AW/91/13 – 22 The Drive – front wall – 12-6-2013

OBJECTION: Proposed front wall and gates – 22 The Drive – AW/91/13 within the Craigweil House Conservation Area AND Area of Special Character

PLAN NO 630/4A

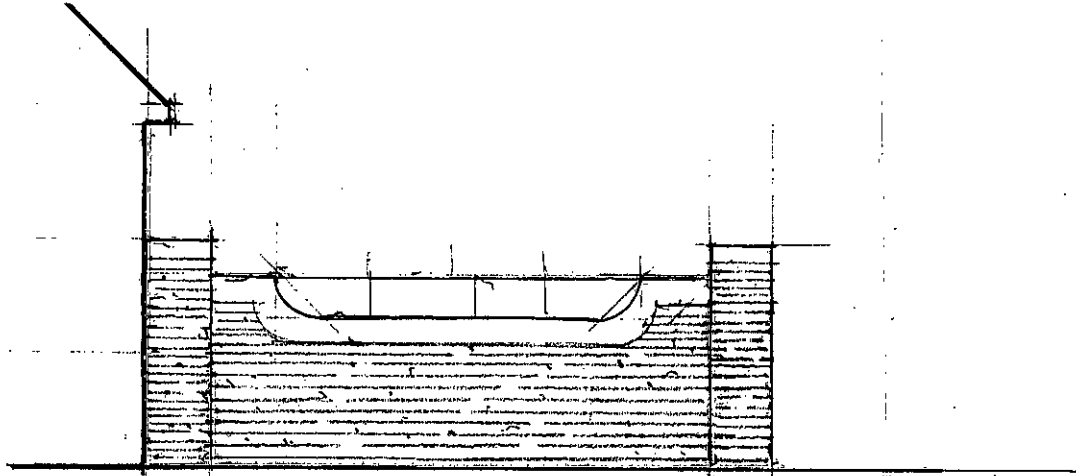
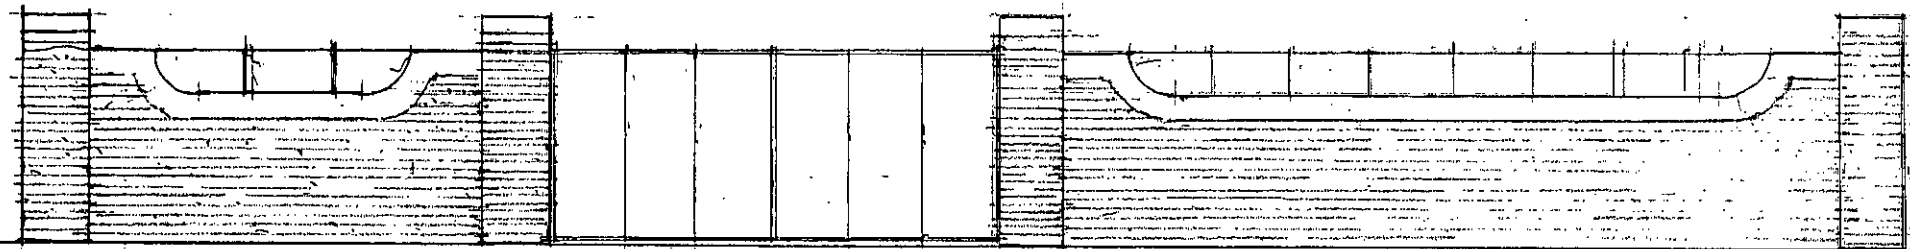
The applicant makes no claim that the planning proposal *'preserves or enhances the character or appearance of a Conservation Area or its setting'* and we say that it does not and that the application should, therefore, fail. CHECAA contends that the insertion of a hard brick wall at this point will be ugly, unsympathetic to the character of the area and damaging to the special, individual setting of this precious little 'time capsule'.

If enclosure is deemed necessary then, following the CA Statement, it may be better and undamaging to have the existing *'pleasing sense of enclosure'*, described by the English Heritage Historic Areas Adviser, maintained with attractive shrubs. Brick walls and iron fencing – probably bent light steel and not genuine solid Sussex wrought iron – have no place in this location and will represent a destructive, not enhancing element, in our view. *Furthermore, we consider, if granted, then compliance with 1m height should prevail.*

TYPICAL SECTION.

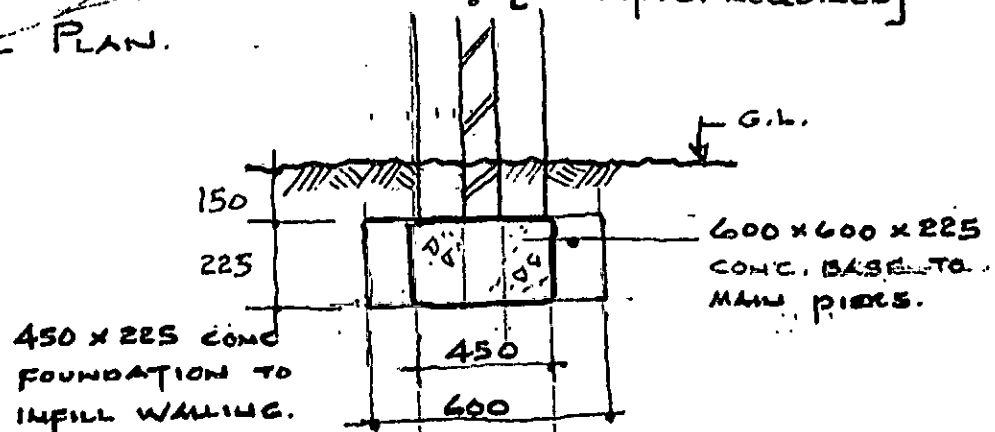
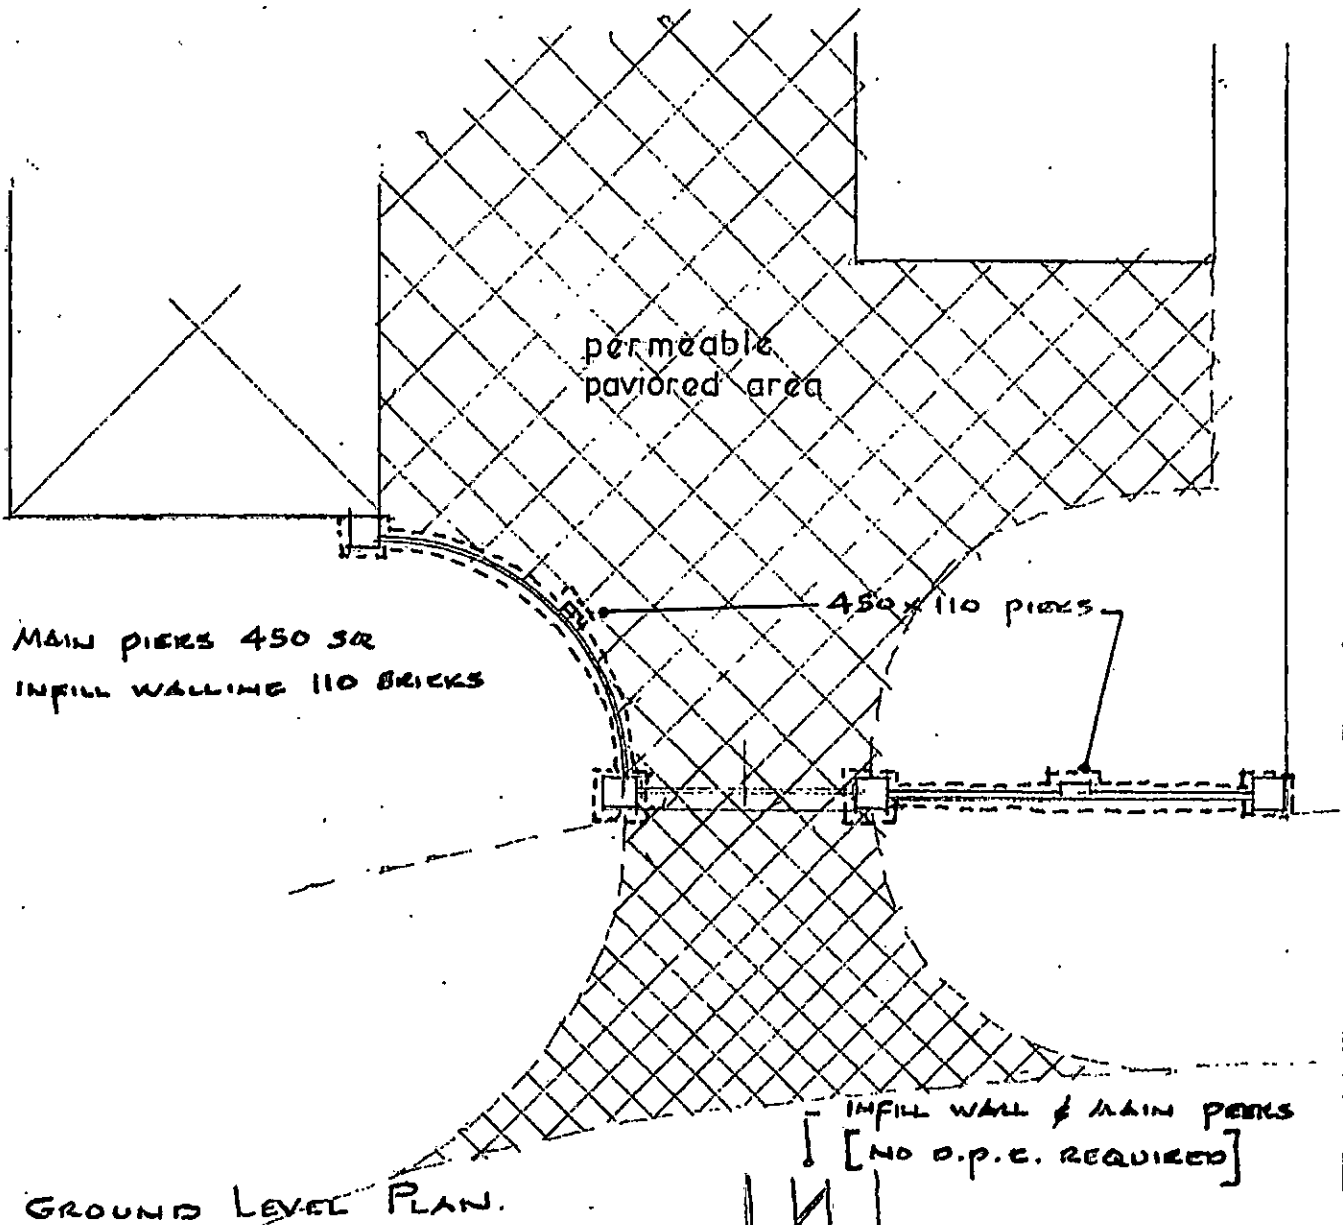
Mention is made in the index online of a 'Tree Survey' but there is none – merely a drawing claiming to indicate tree locations – by someone, but not an arboriculturalist! Elsewhere, it is mentioned that the writer has the telephone number of Ian Brewster, the District Principal Arboriculturalist; that the foundations will be hand dug and that ***'bridging arrangements will be made if any evidence is found of potential damage to the trees'***. Presumably – and it is not for us to presume but for the applicant to state his intentions – this applicant makes oblique reference to the requirements of BS5837: 2012 and to encountering roots of the nearby trees which are of great public amenity value. There is no facility for ***'bridging'*** tree roots – they grow on the circumference, they are not drains - but, by implication, the risk to trees is acknowledged and we ask that these be inspected by the ADC Arboriculturalist; that Tree Preservation Orders be made for their protection if appropriate and that instructions as to any form of construction technique be given if this application is granted.
